CITY OF PORTLAND, MAINE

PLANNING BOARD

August 17th, 2012

Project Name: **Phase II Development Jordan's Meat site**
Project ID: 2012-491 CBL: 29-3-L
Address: 203 Fore Street, Portland
Applicant: Fore India Middle, LLC, Opechee Construction Corporation
Planner: Jean Fraser

LIGHTING PLAN

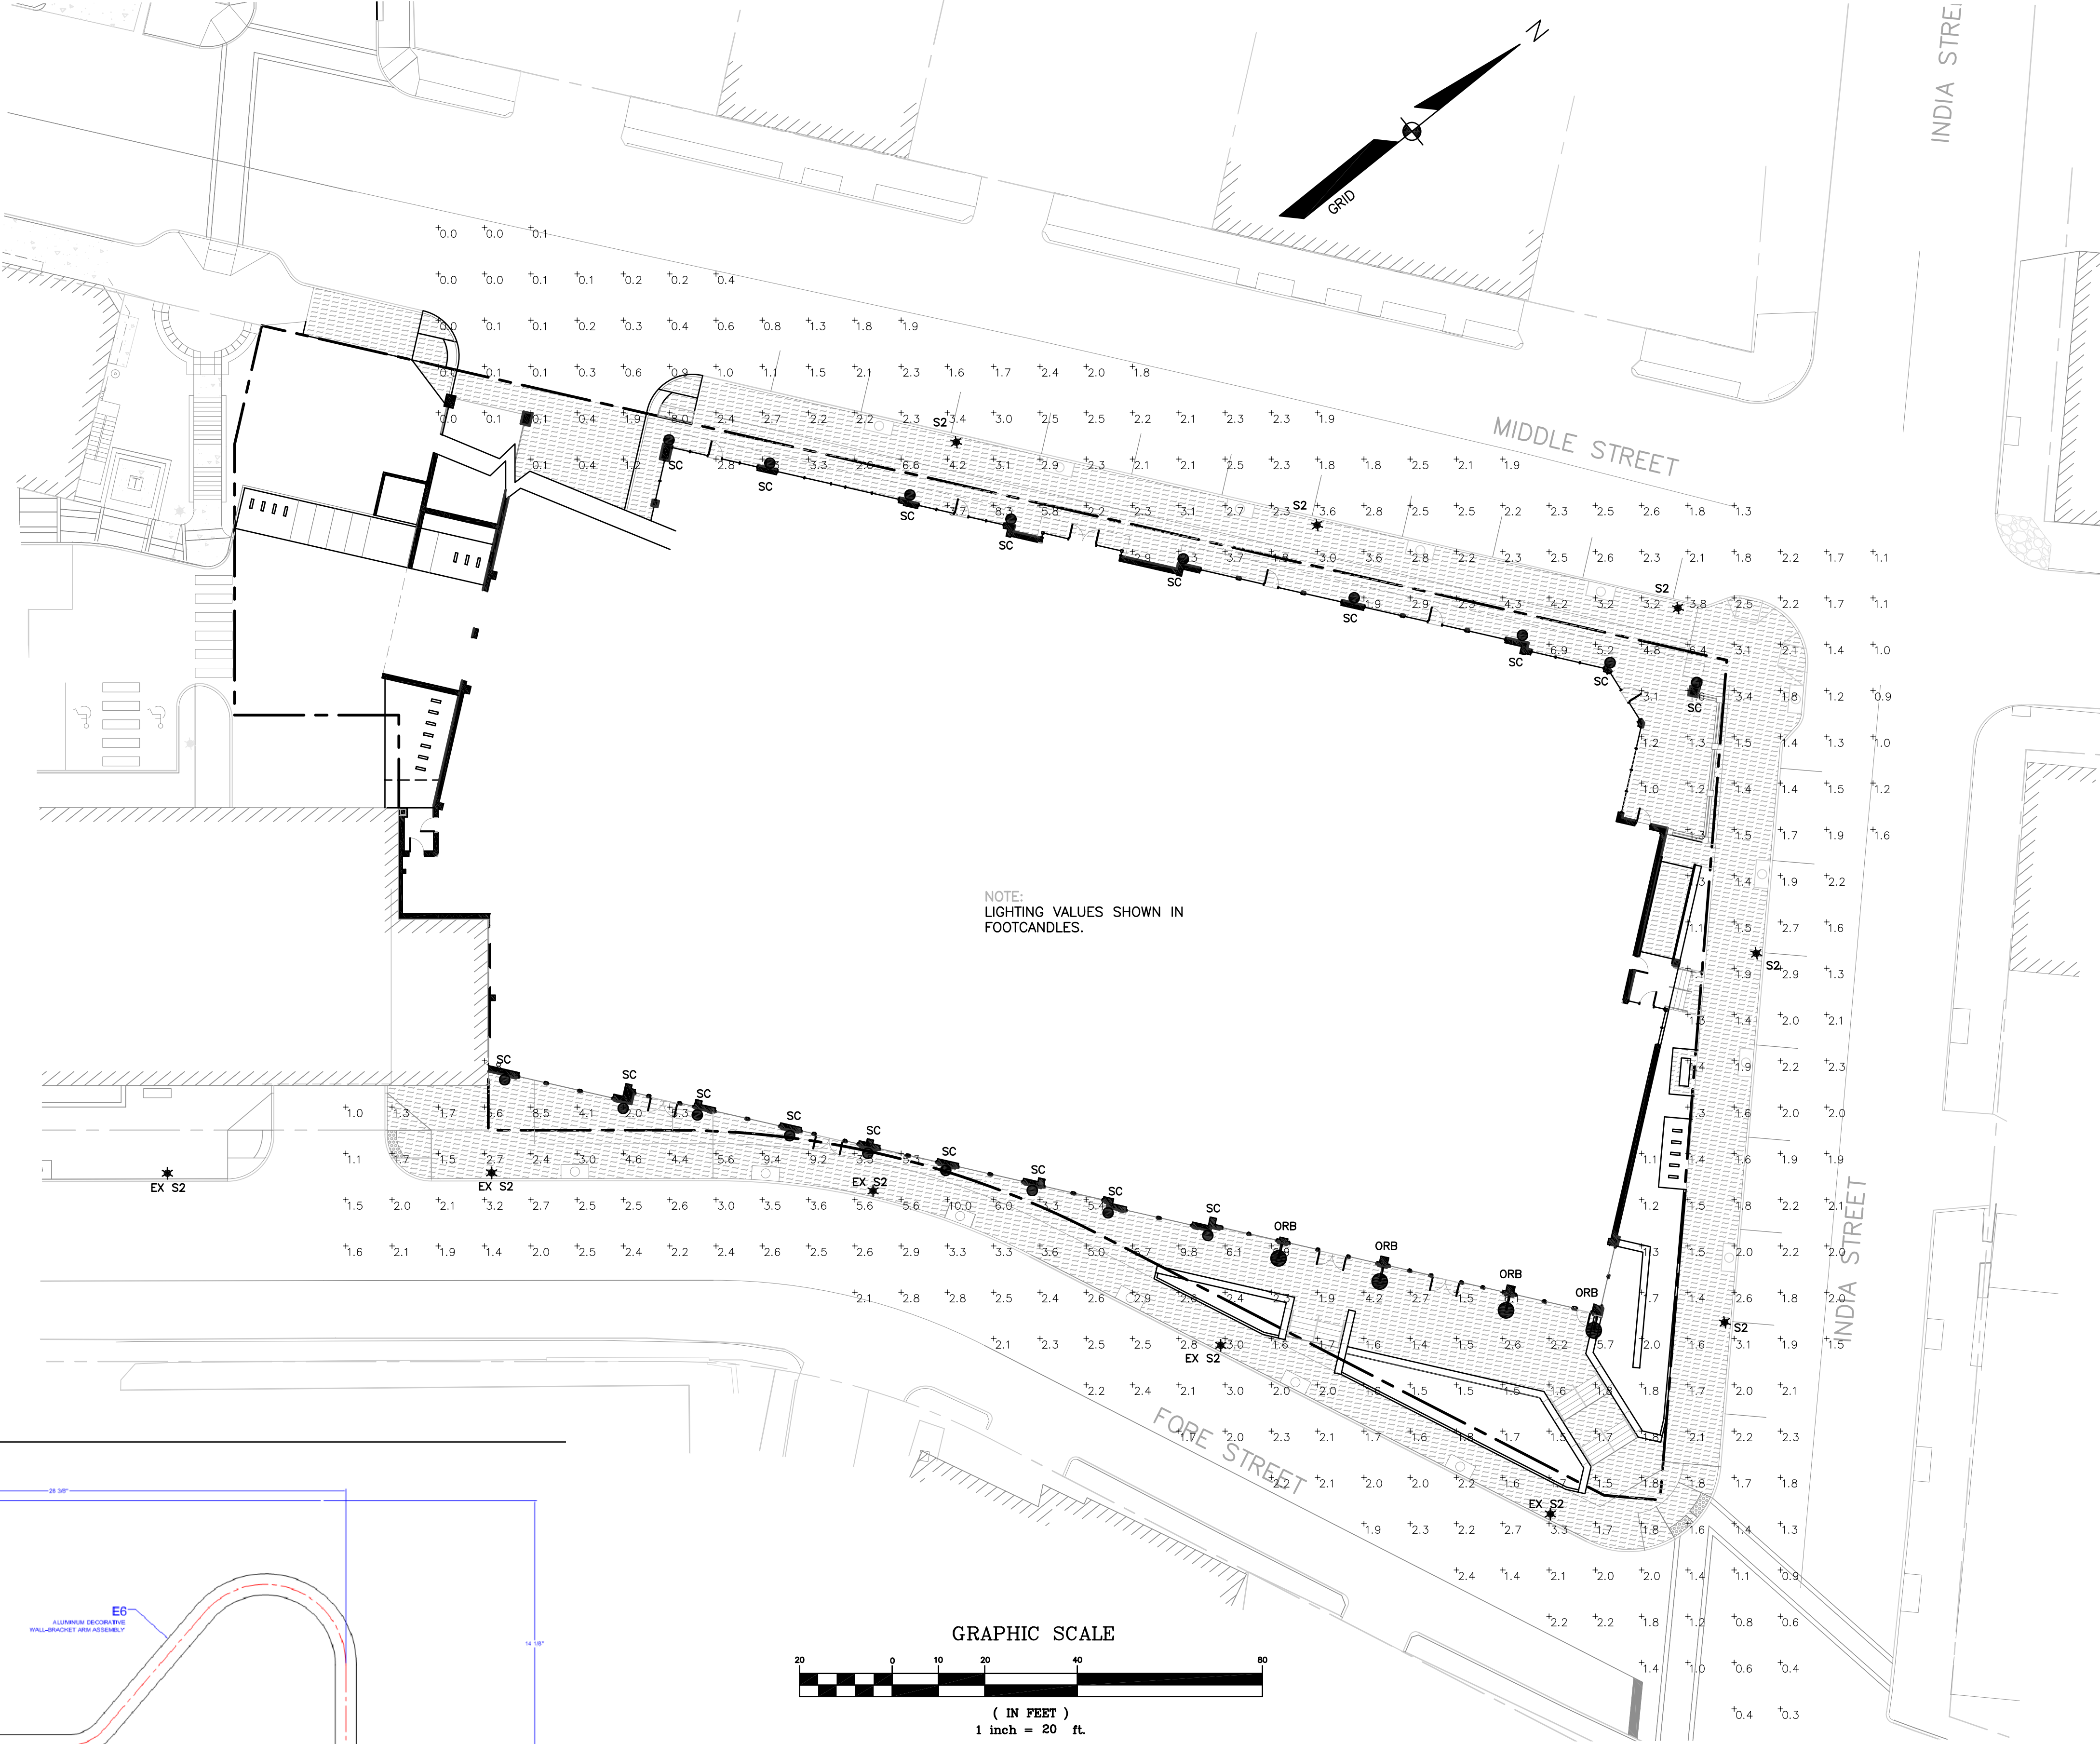
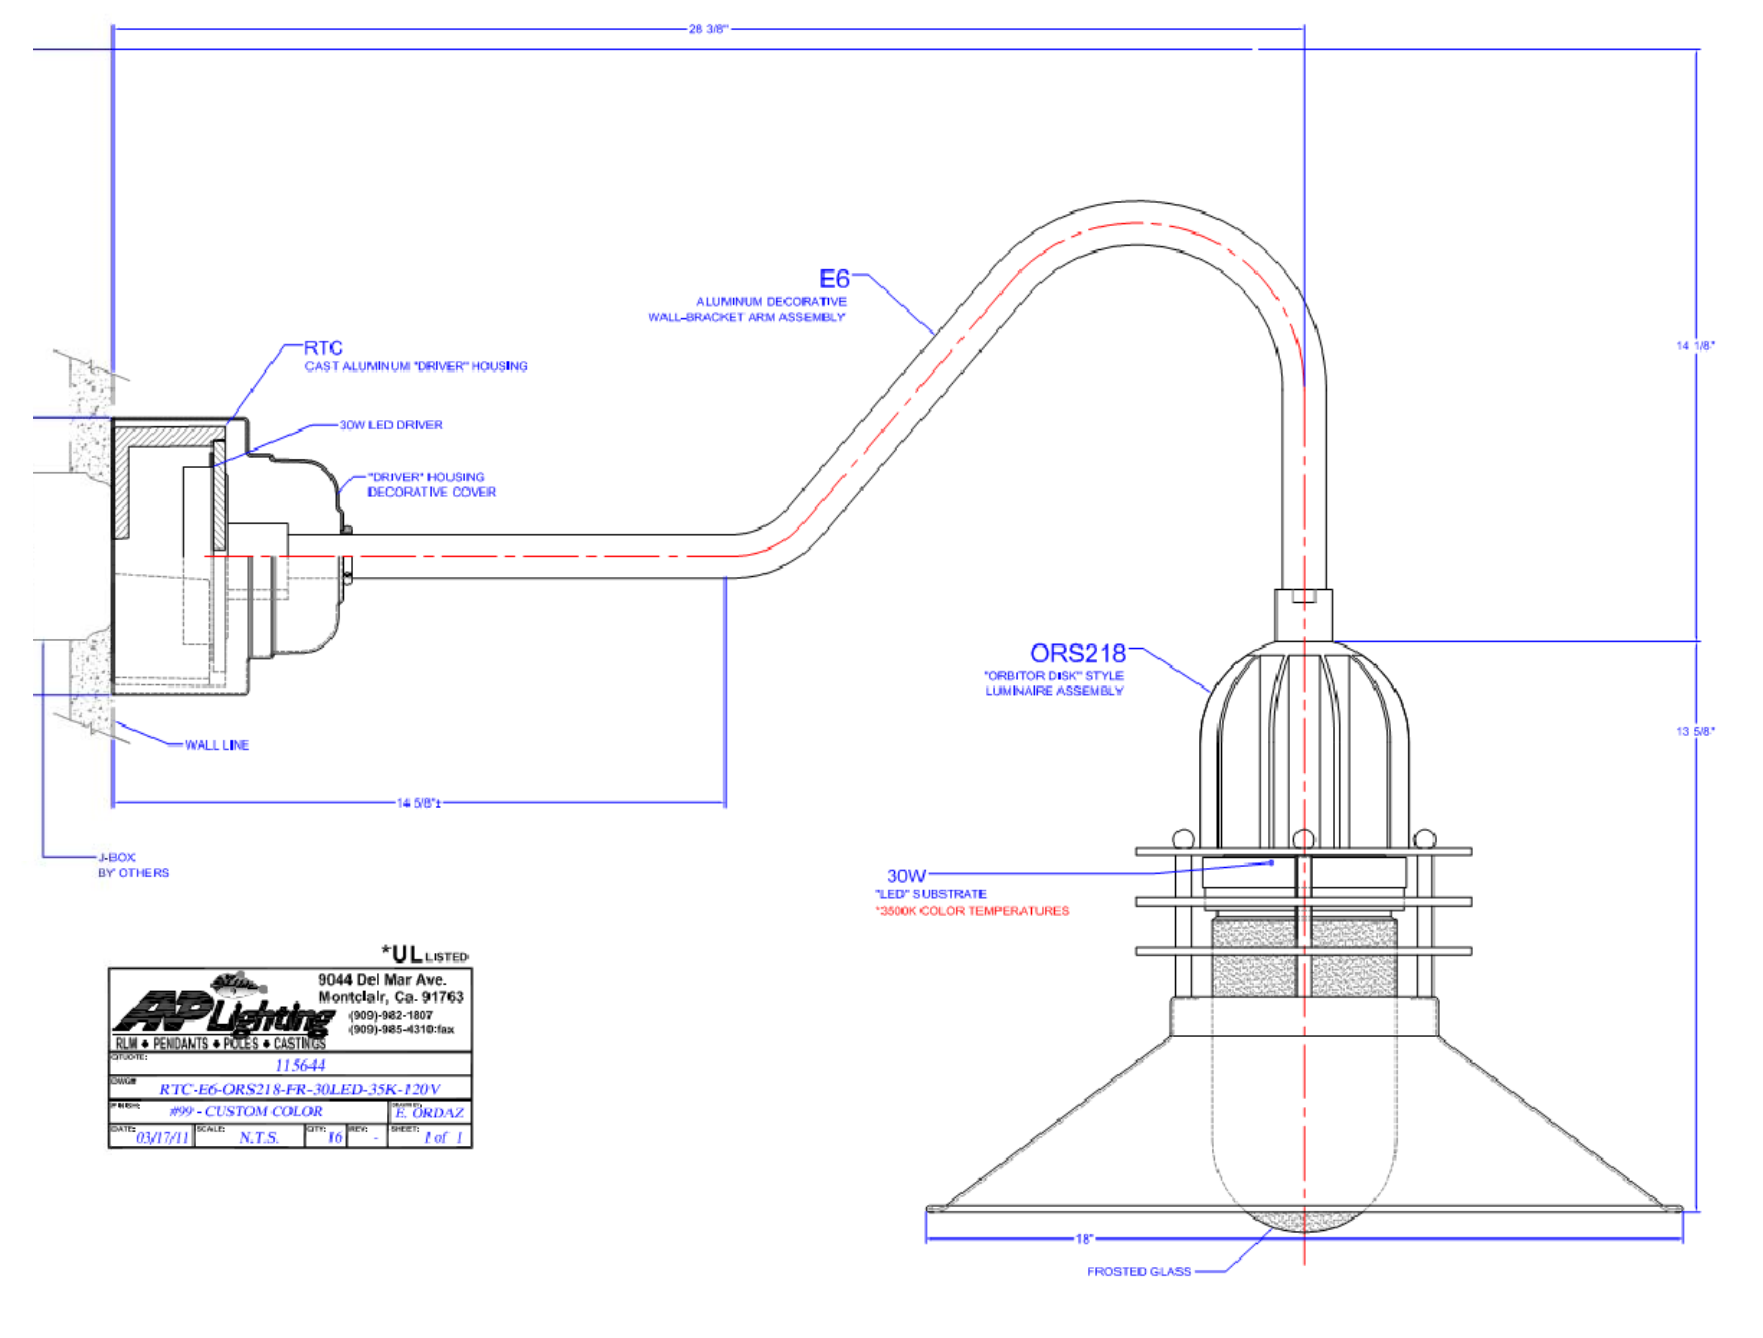
- vii. That the wall sconce under the glass canopy along the retail entrances shall be revised (regarding lamp wattage or spacing) so that the photometrics meet *Site Lighting Standard 12.2.3*); and
